Our Ref: LU/48/13/CLP
Your Ref:

Application for Lawful Development Certificate for a Proposed Use or Development

Development Application for certificate of lawfulness for proposed removal of hipped roof and replacement with gable end and extension of dormer at first floor level

Location 35 Grove Crescent Littlehampton

SITE PLAN - 1/500

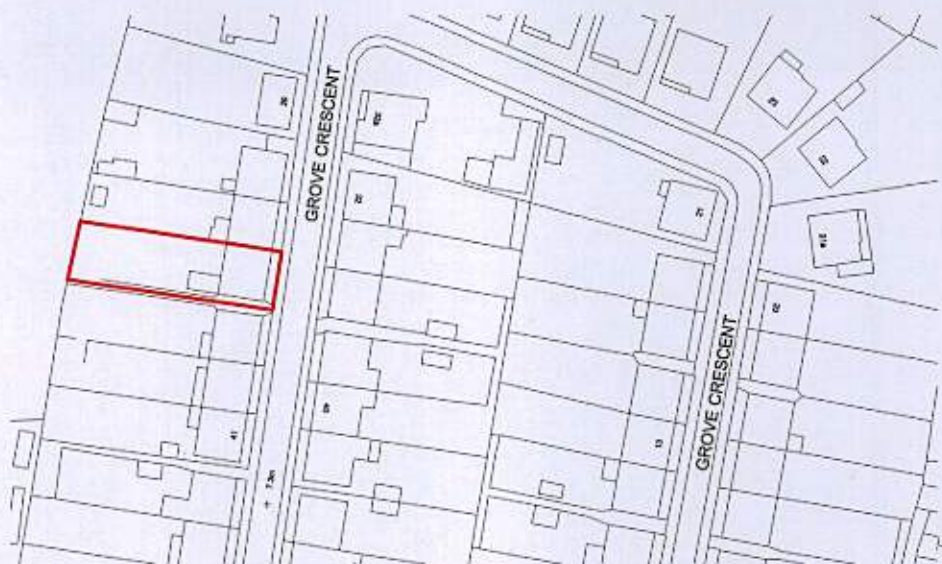
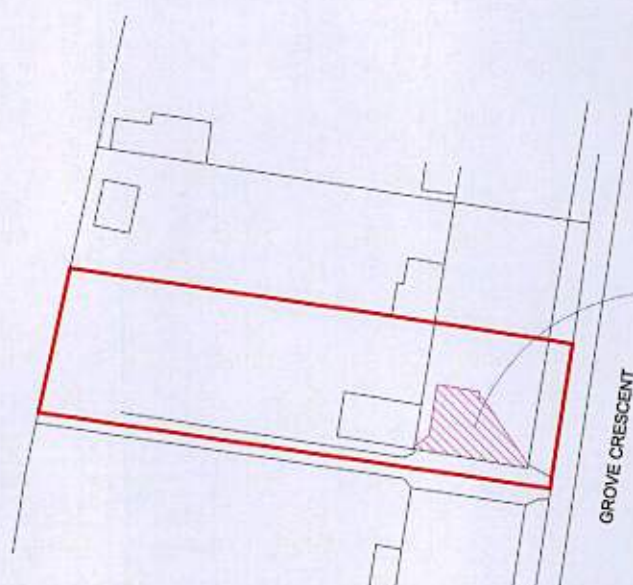
Please submit 1 electronic or 3 paper copies of a revised block/site plan with the proposed works clearly hatched or highlighted in accordance with the guidance notes available on our website detailed below (click on National List).
